23rd June 2020

Application No: BN/54/20/HH
Site Address: Minstrels Barn Church Lane Barnham PO22 0BX
Description of works: Proposed single storey extension to courtyard area and changes to fenestration. This application affects the character and appearance of the Church Lane Conservation Area. The application affects the setting of a Listed Building.

OWPC27921

DRAWING NUMBER
13062/101

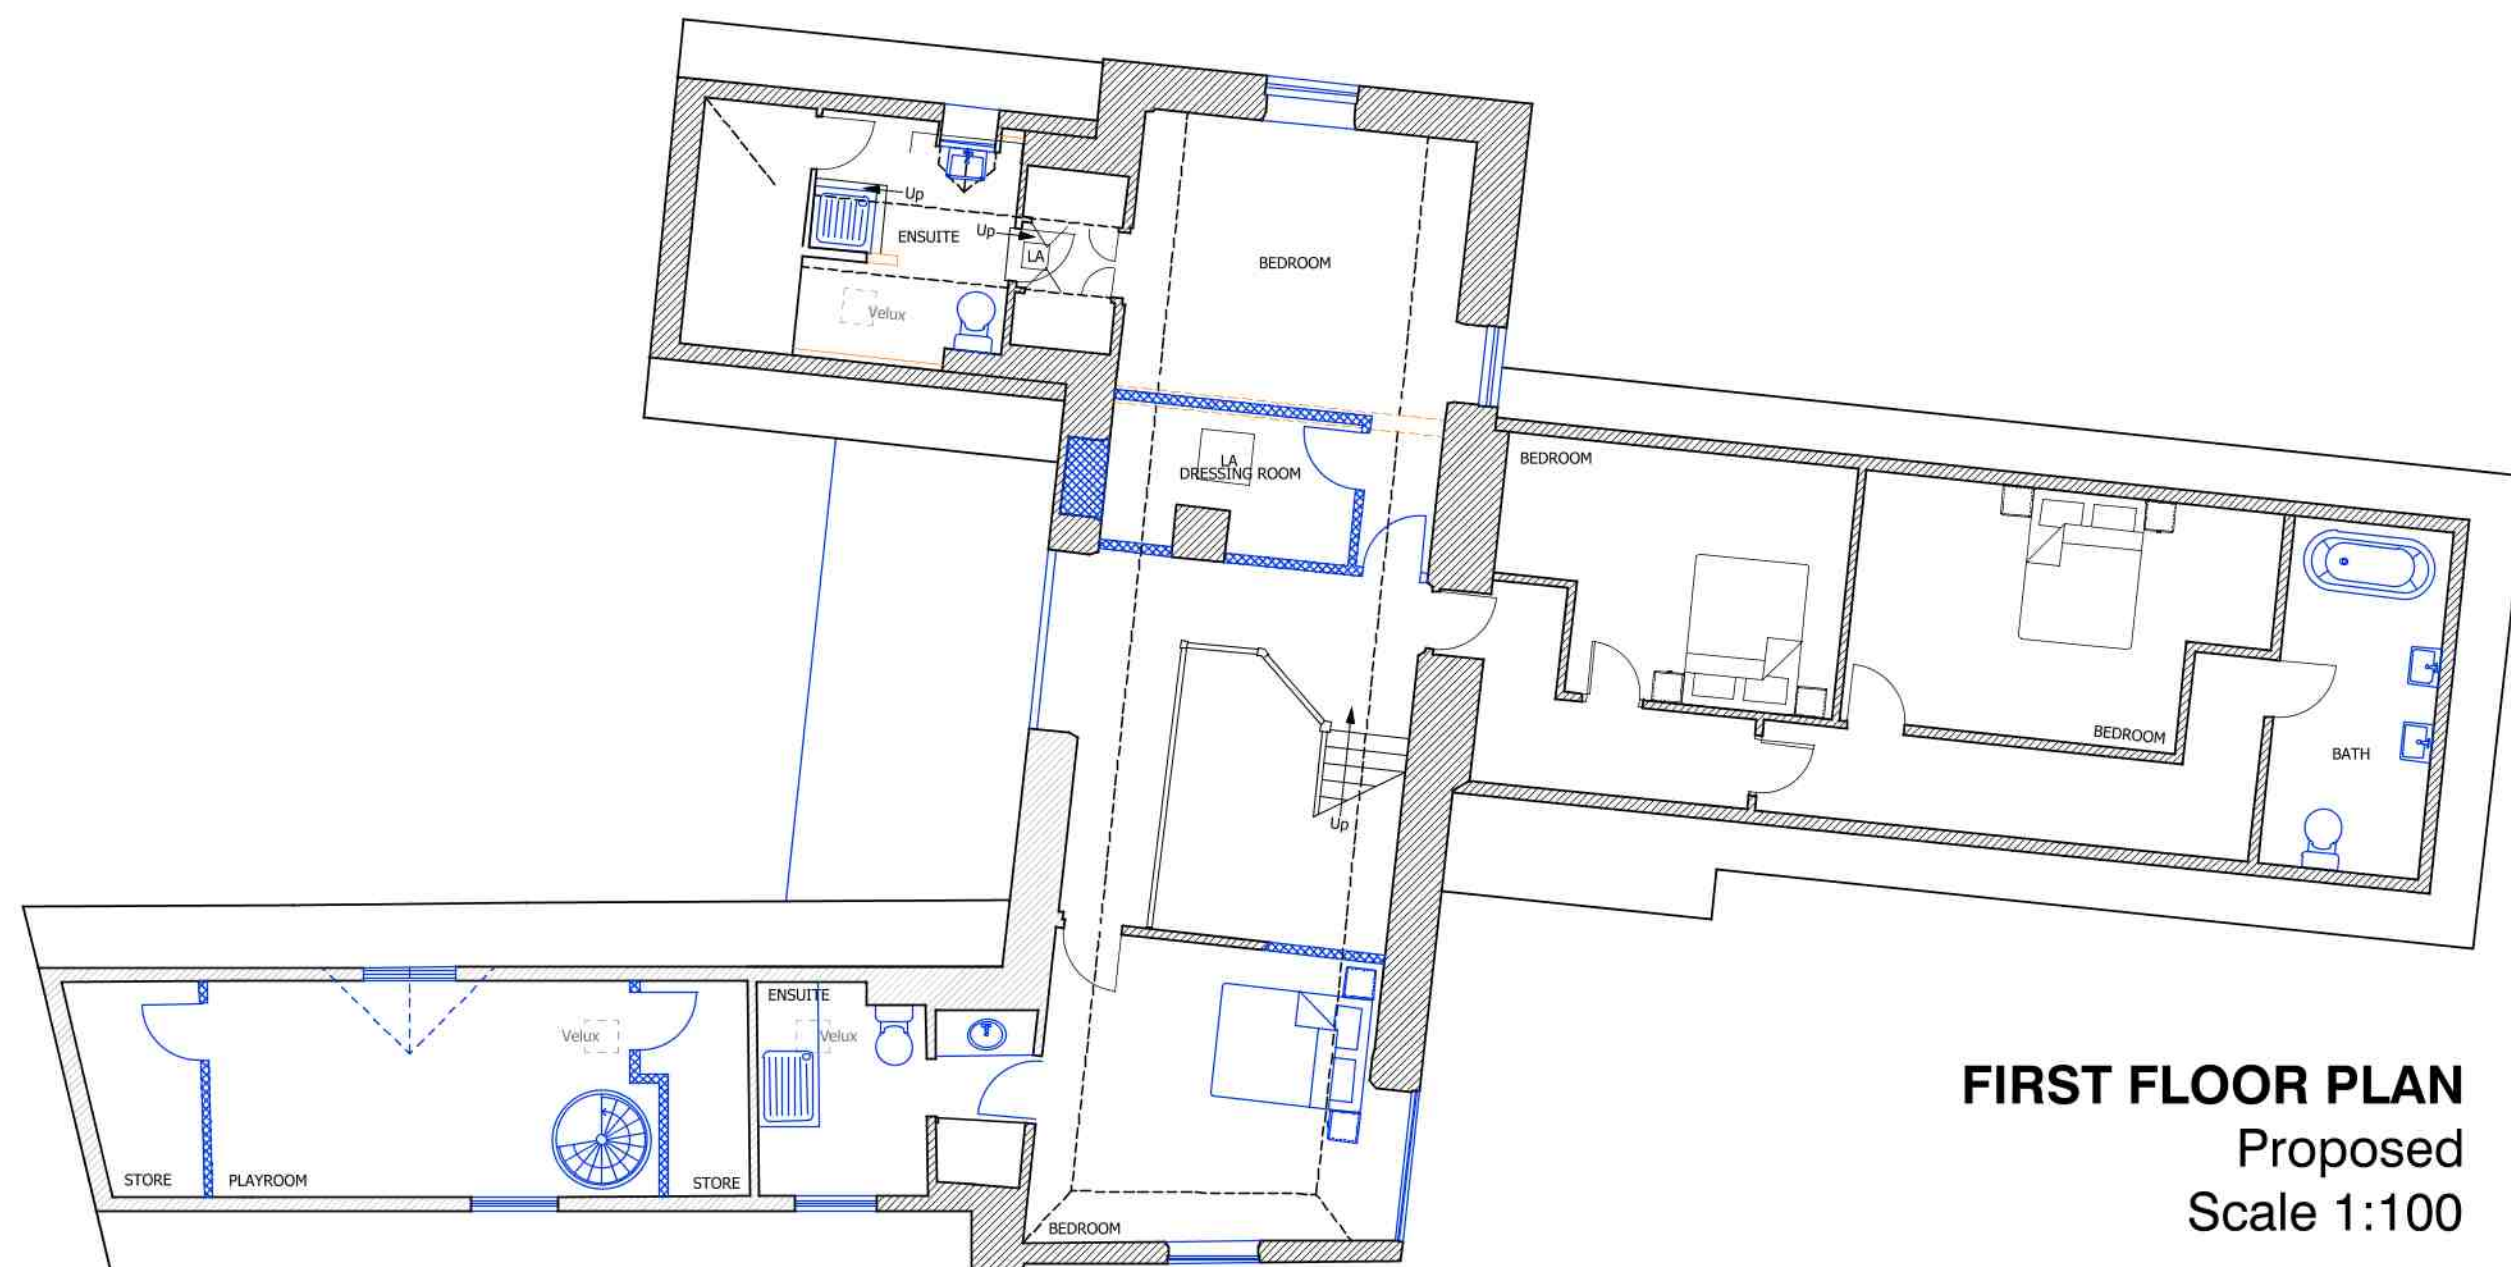
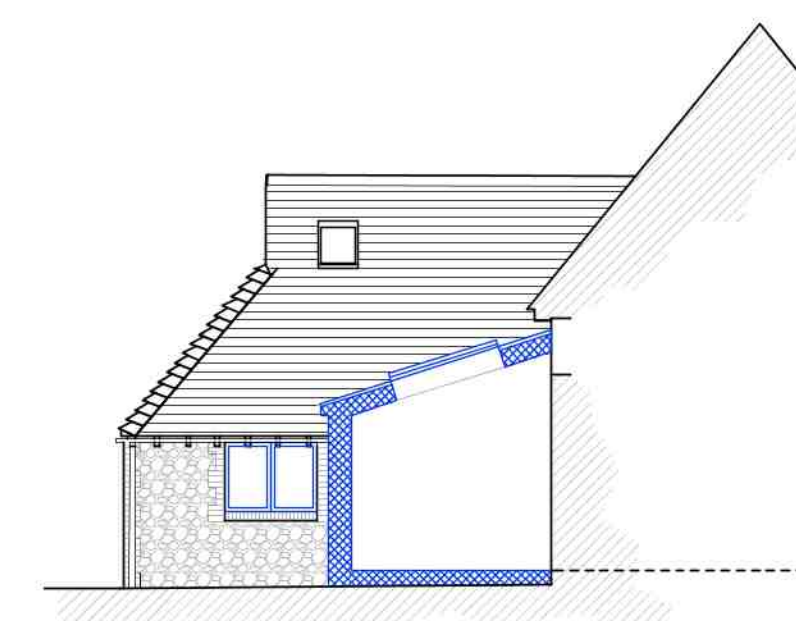
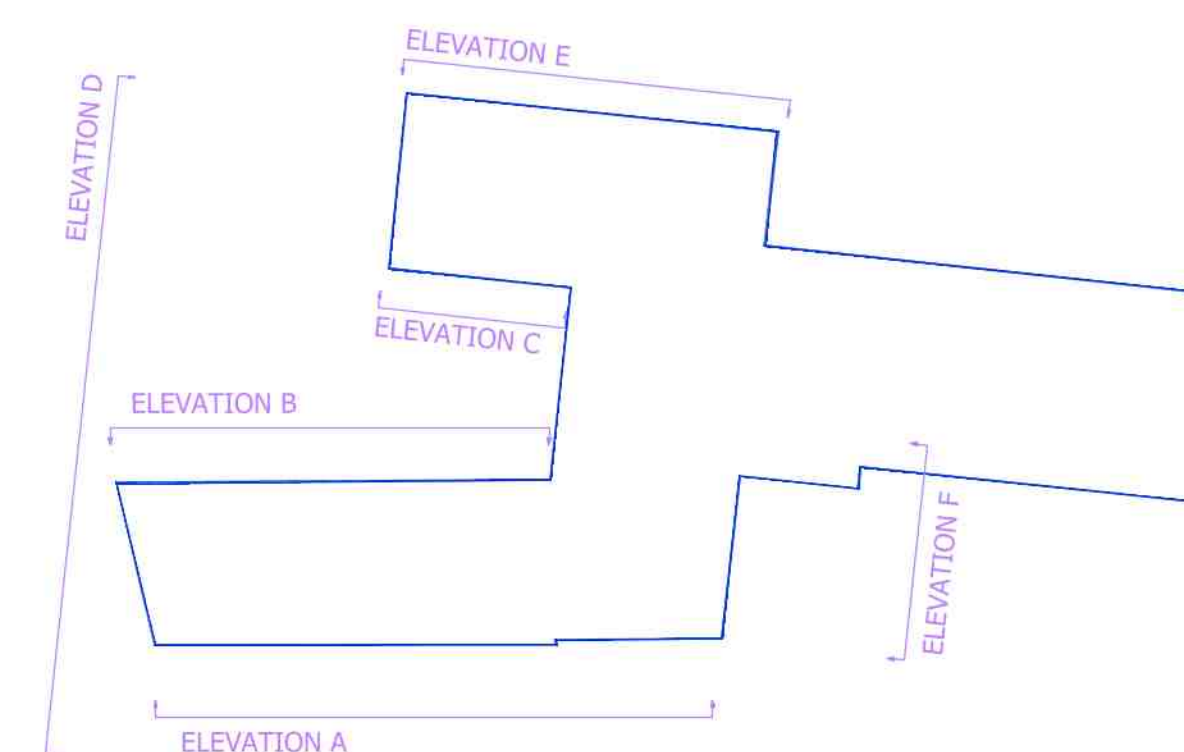
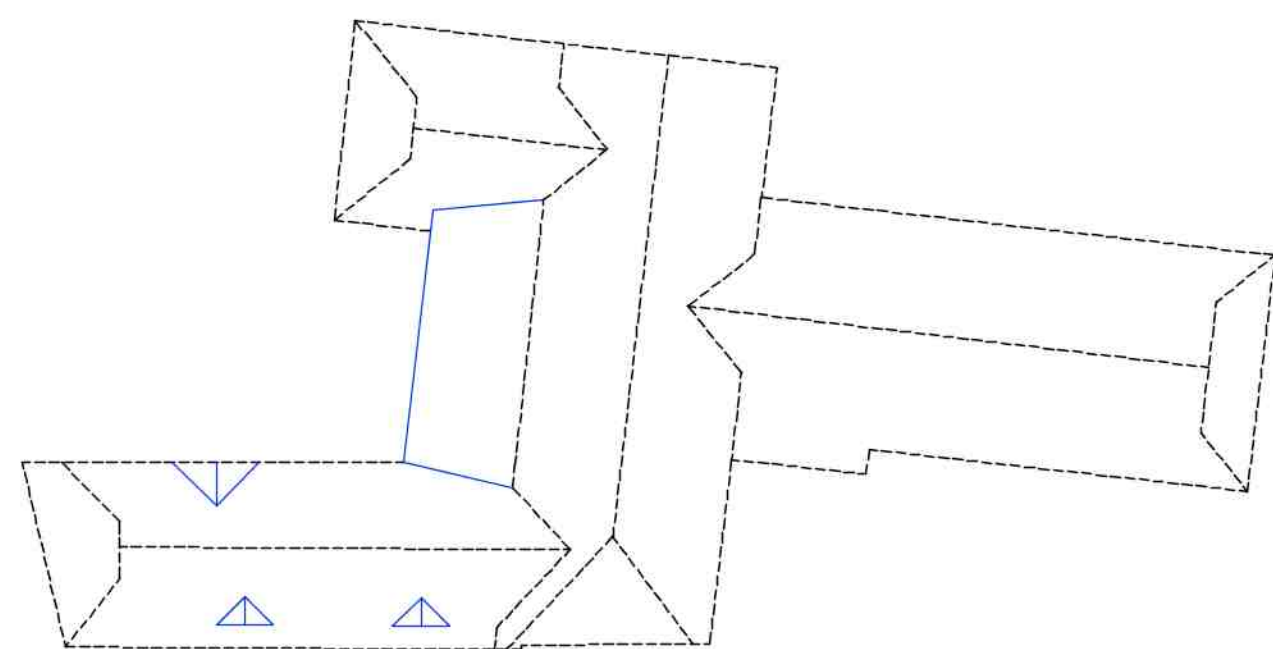
The Panel see no objections to the proposed extension but consider the two following matters unsatisfactory:
(1) The existing windows with their subtle 4 light divisions, i.e with a central vertical glazing bar/mullion introduced into each individual side hung casement, provides an attractive and very appropriate rural appearance to the building. The quality and attractiveness of the fenestration is further enhanced by subtly profiled mullions. The replacement of these windows with standard plain side hung casements will lend a much more domestic appearance to the building and denude it of a fenestration which contributes so much to its character. As such the proposed changes will also have a negative impact on the character and appearance of the conservation area.

(2) It is accepted that there are existing small dormer windows in the roof over the garage area but to introduce further dormers on the street elevation of the property will detract from its rural character and increase the domestic paraphernalia. Note how the plain roofs of the building in tandem with those of Field Cottages to the south contribute to the rural character and appearance of the conservation area.

For these reasons the Panel consider that the proposal will materially detract from the character and appearance of the building and the conservation area in conflict with the relevant paragraphs of the NPPF 2019 and policies contained in the Arun District Local Plan relating to the protection of designated and non-designated heritage assets.
